Ref: Revised Planning Application M/42/15/HH for Side & Rear Extension to 37 Lane End Road.

Ref: Planning Application M/10/15/HH for Side & Rear Extension to 37 Lane End Road. (Refused)

I am writing to oppose the Revised Planning Application for the extension planned for 37 Lane End Road by Mr & Mrs Joseph.

PROPOSED GROUND FLOOR PLAN 1/50

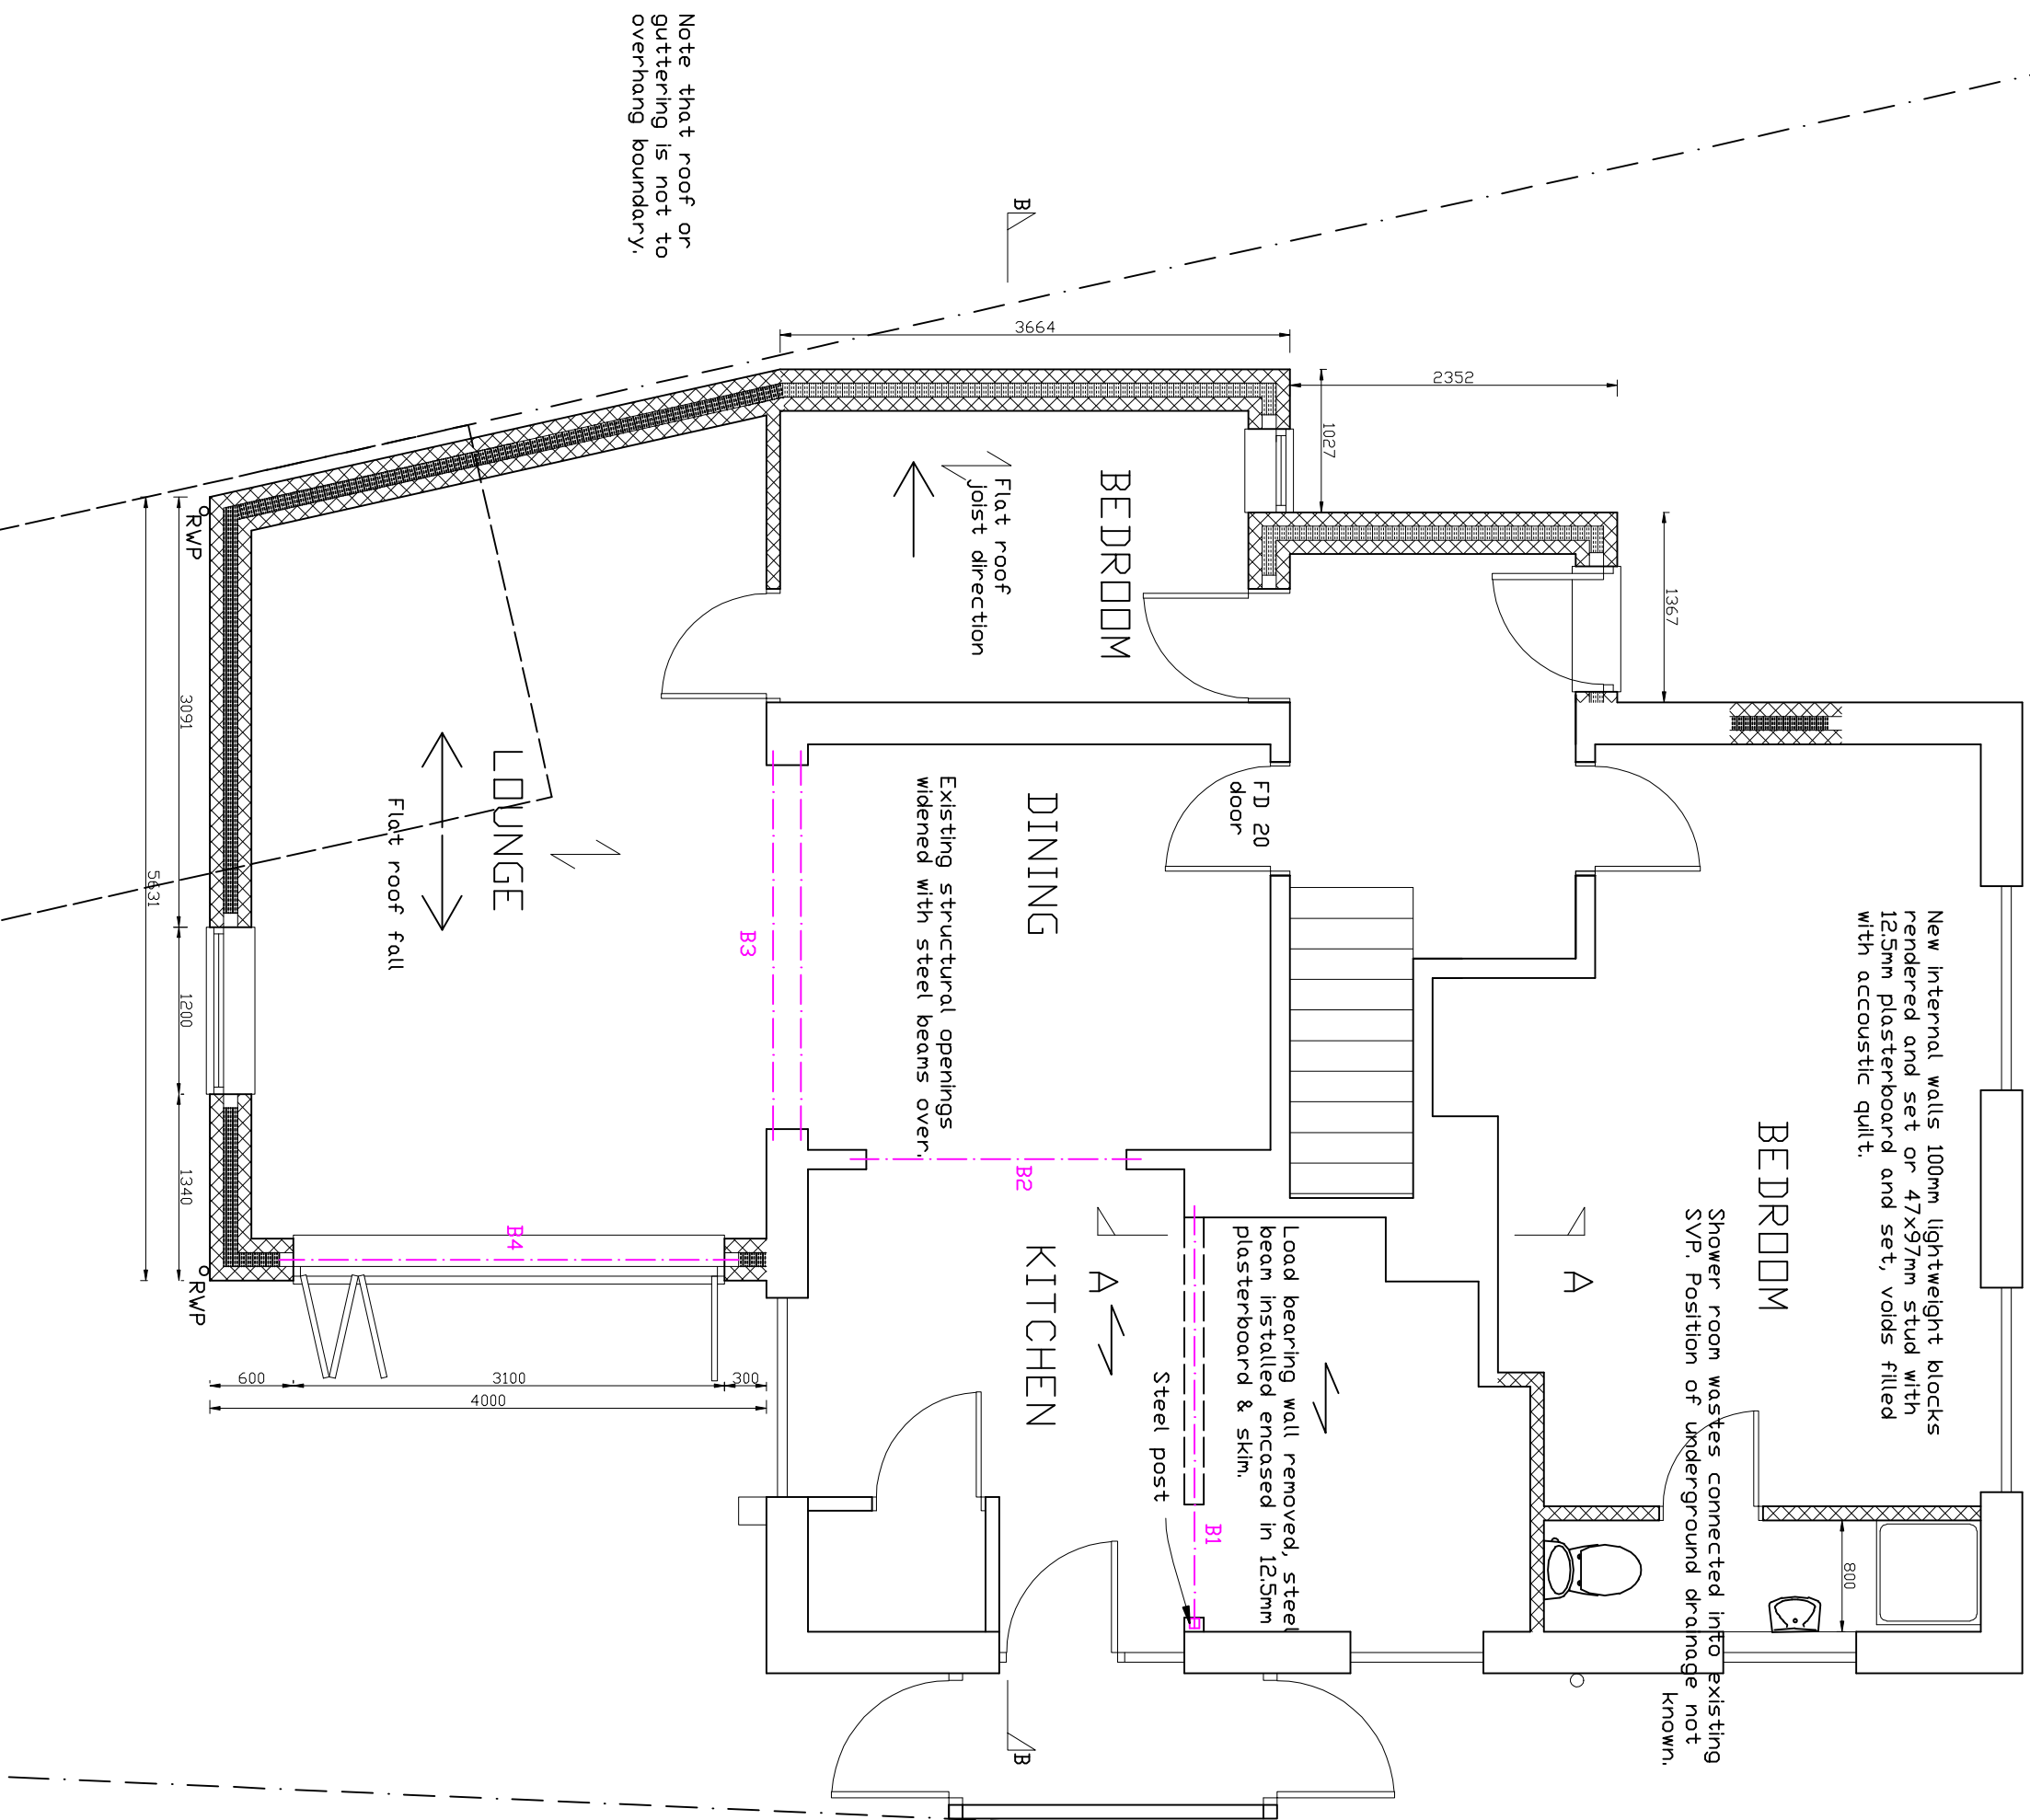
- The corner of the proposed wall of the extension would be only 71 inches (1800cm) from my front door, it is 40 inches (1016cm) to the centre of the chain link fence which divides our properties.

In summary I believe that the completion of the proposed building work, in particular how close the wall on the border between our properties will significantly decrease the amount of daylight / sunlight into our property and also the concerns I have about the excavations etc. I therefore again, wish to formally oppose the granting of the Revised Planning Application for such building works.

SECTION AA

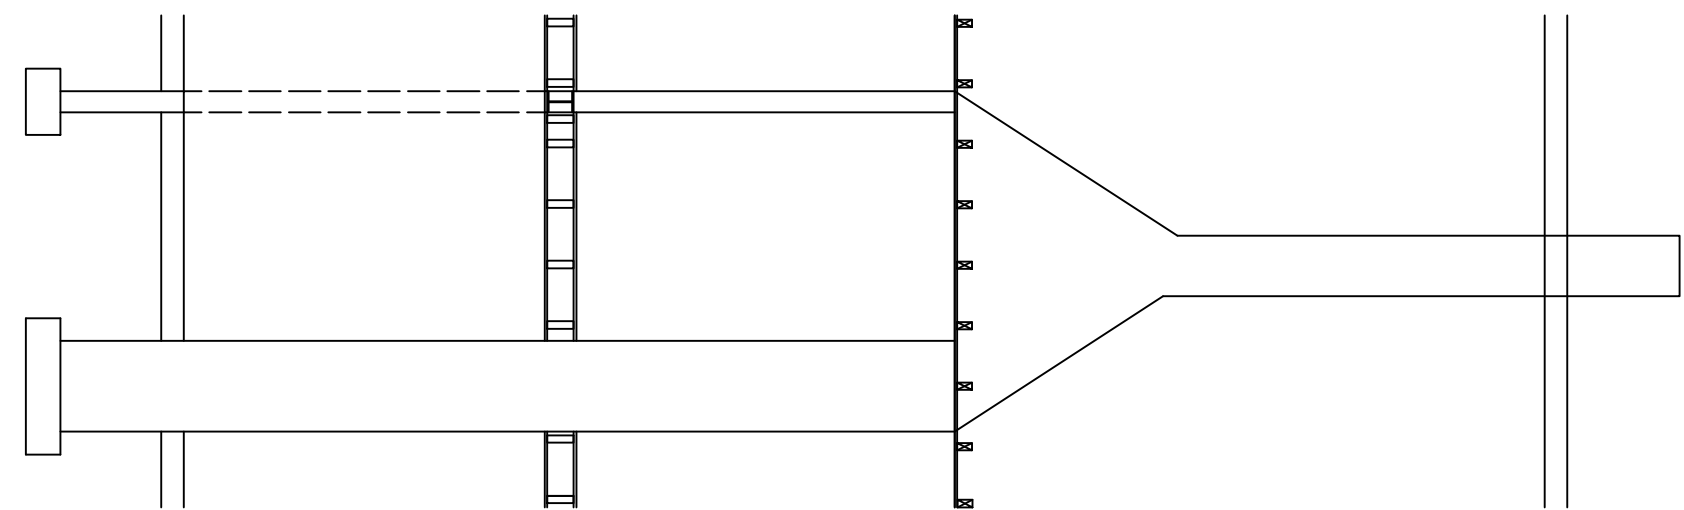
- Material Consideration The proposed height of 2.7 to 3 metres takes the extension well above the height of my guttering and would therefore still significantly reduce the amount of natural light through my front door, I had my front door changed some years ago to one that has large glass panels to maximise the amount of natural light into my small hallway, this was done as both my wife and I are disabled and have difficulties with the very basic activity of walking and that means we need to have as much light as possible in our hallway for our own safety.
